PORTLAND MAINE

August 7, 2012

RE: 21 Quiet Lane -- 388A-A-053 -- R-2 Zone - permit application #2012-07-4580

SITE PLAN OF LAND
IN
PORTLAND
MAINE

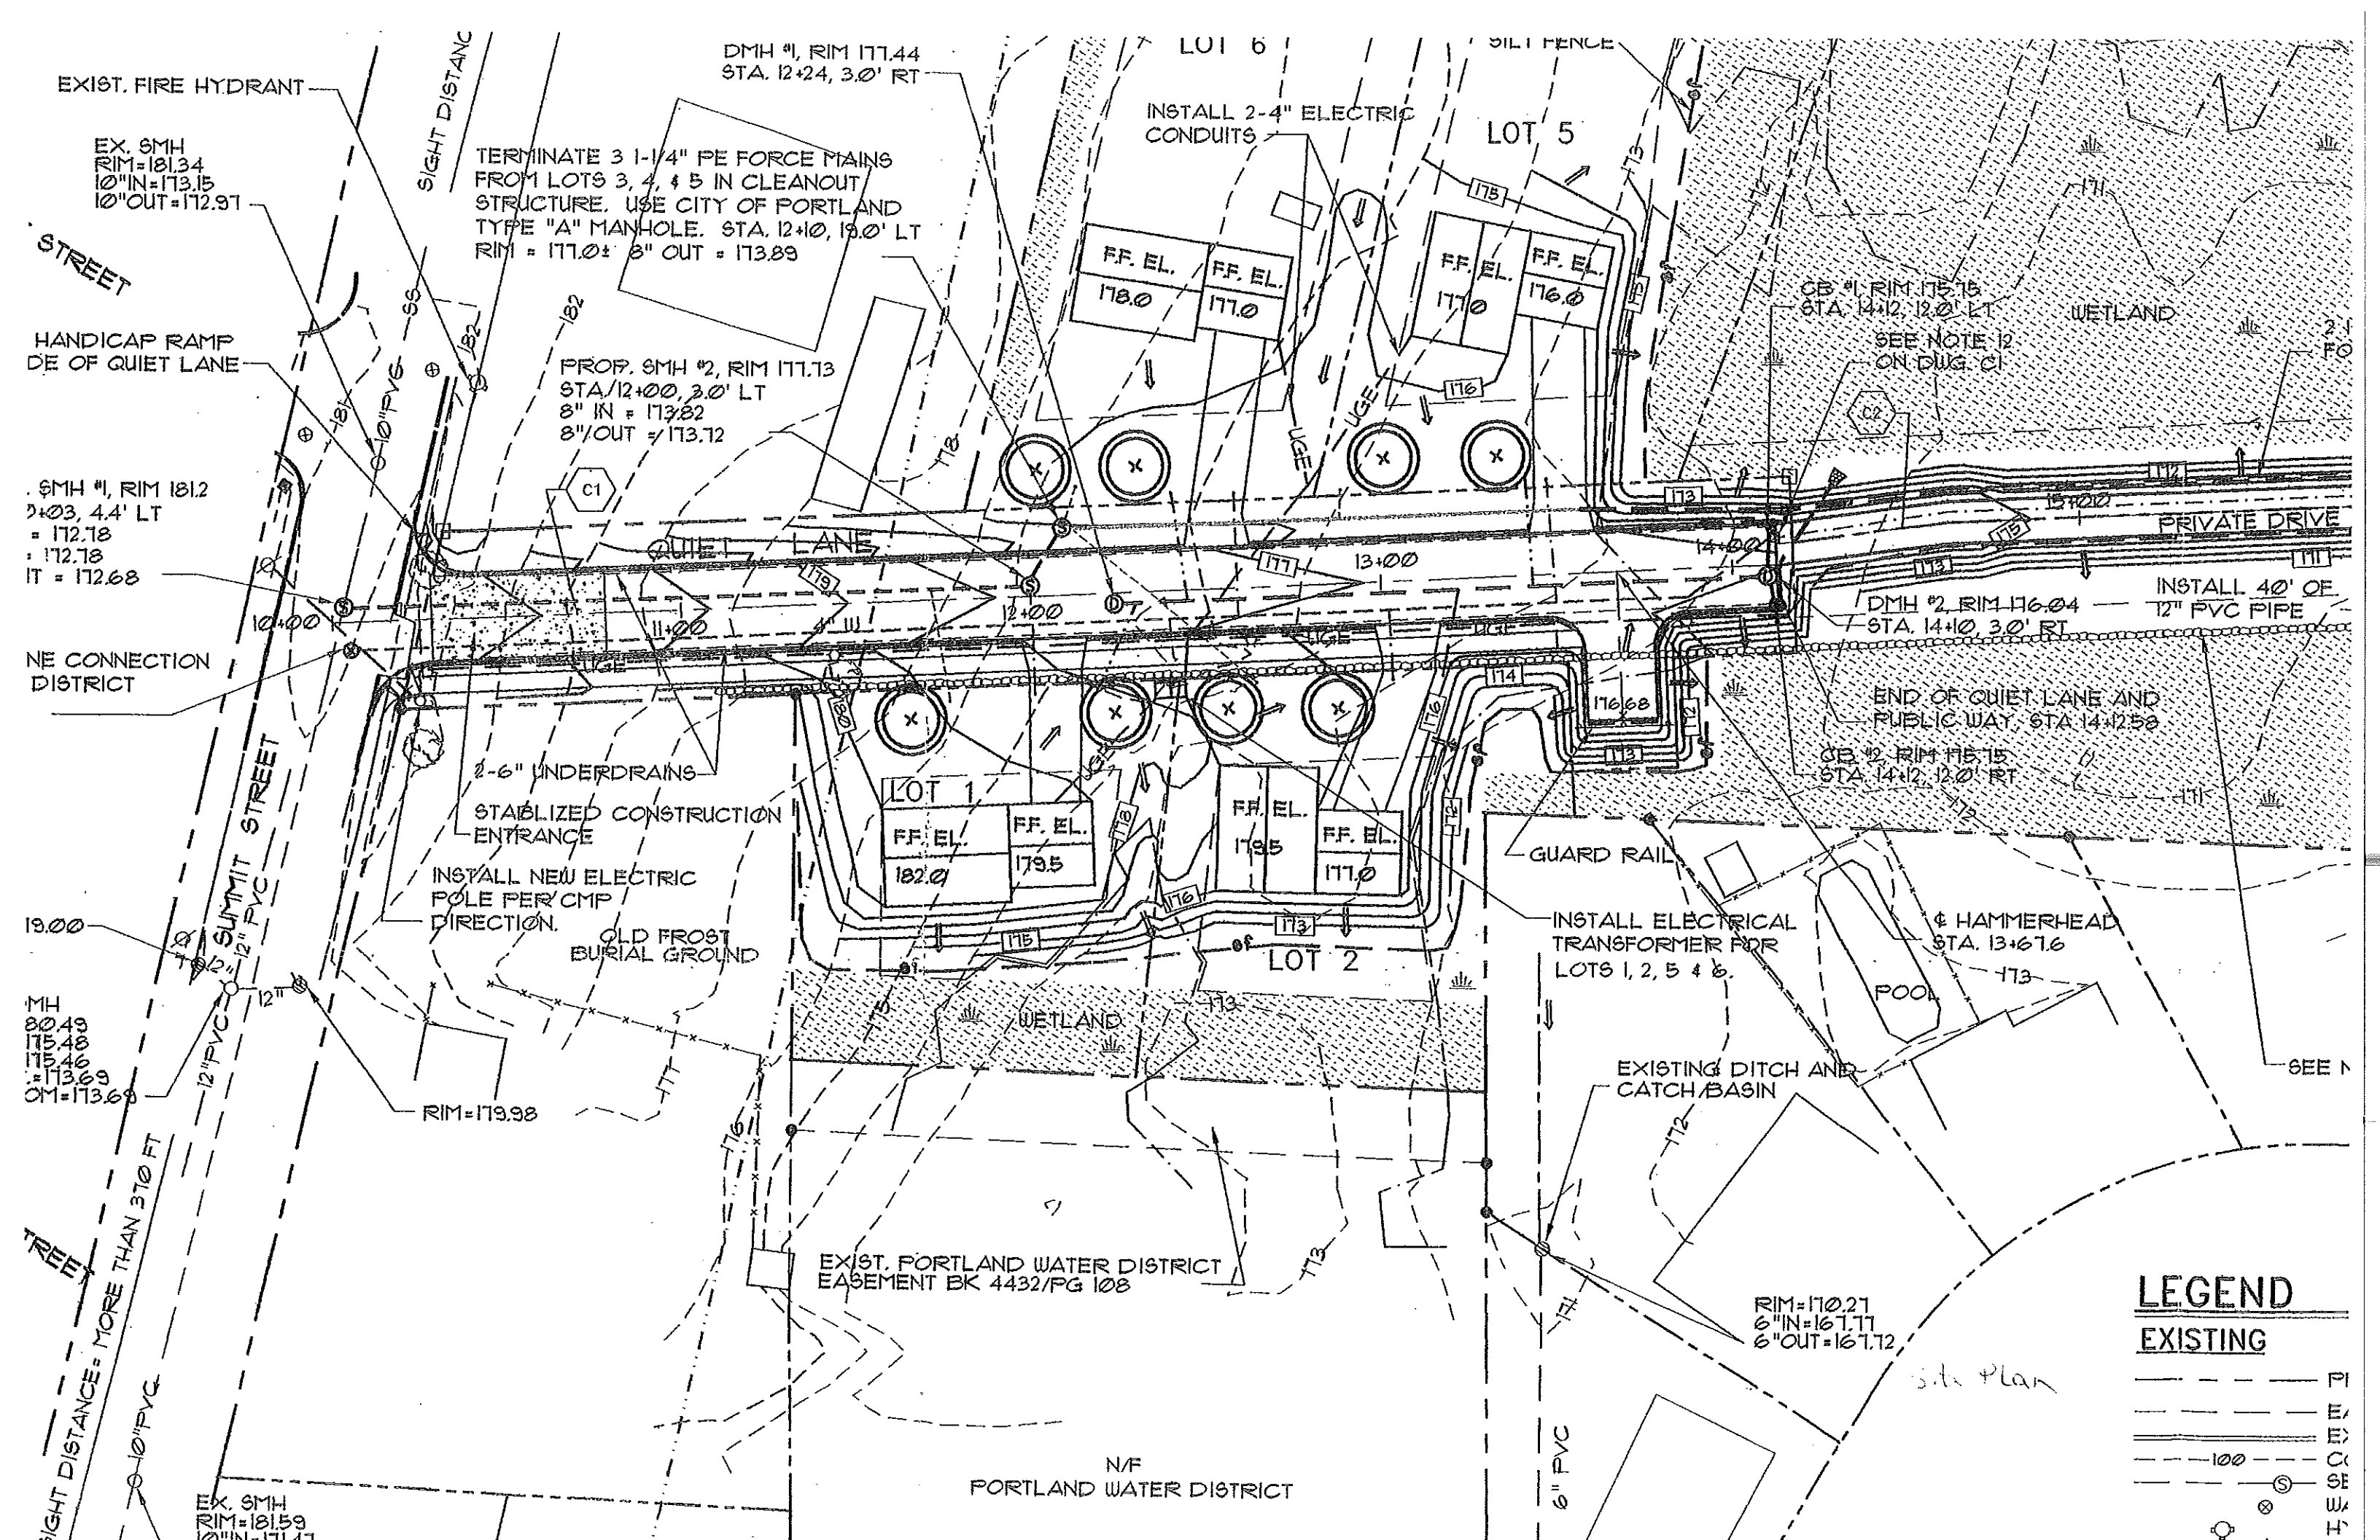
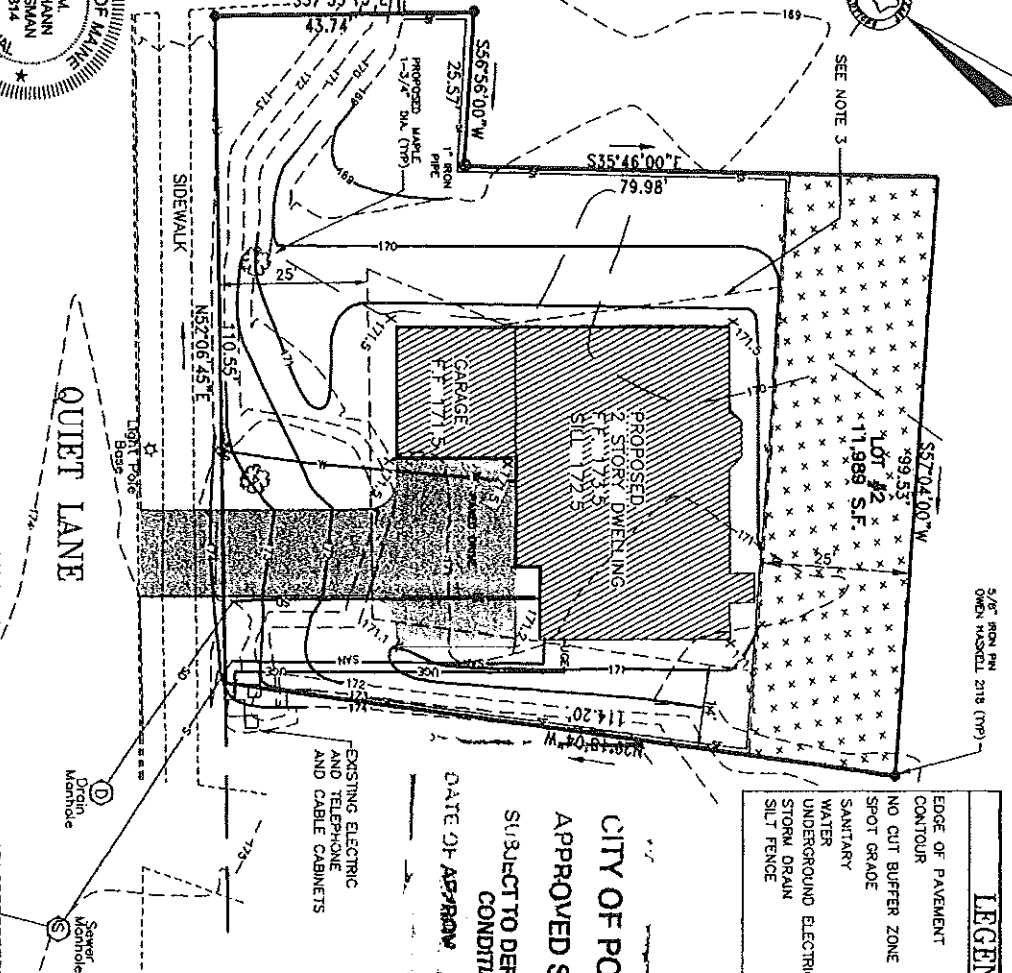
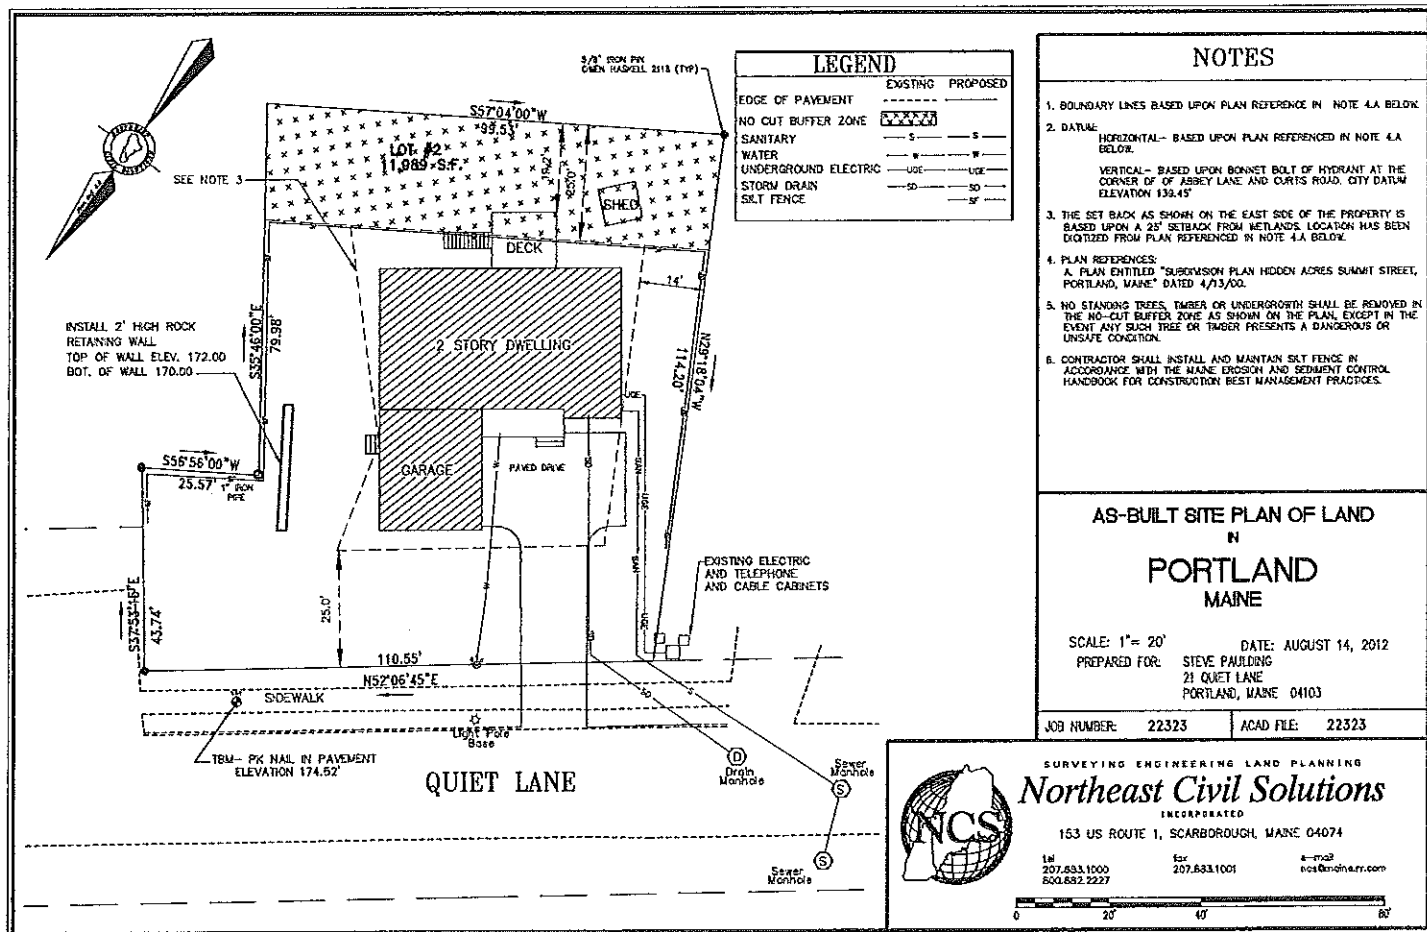
I am in receipt of a permit application to enclose an existing deck as applied for by Wintergreen Solariums. I have the original approved site plan from 2001 which is on file, showing the original house and setbacks including a no cut buffer zone.

First of all, I find no permit on file for the original deck. Such an addition does require a building permit. Apparently the deck was erected without the required review and permit. Based upon the original approved survey site plan, I believe the added deck is located in the required rear setback and within the no cut buffer zone as depicted on the approved site plan (enclosed). The R-2 zone in which this property is located requires a minimum 25 foot rear setback under section 14-80(d)(2).

Your application request is not issuable at this time. If you have any further information to submit verifying a deck permit and meeting the required setbacks, please submit such information as soon as possible.
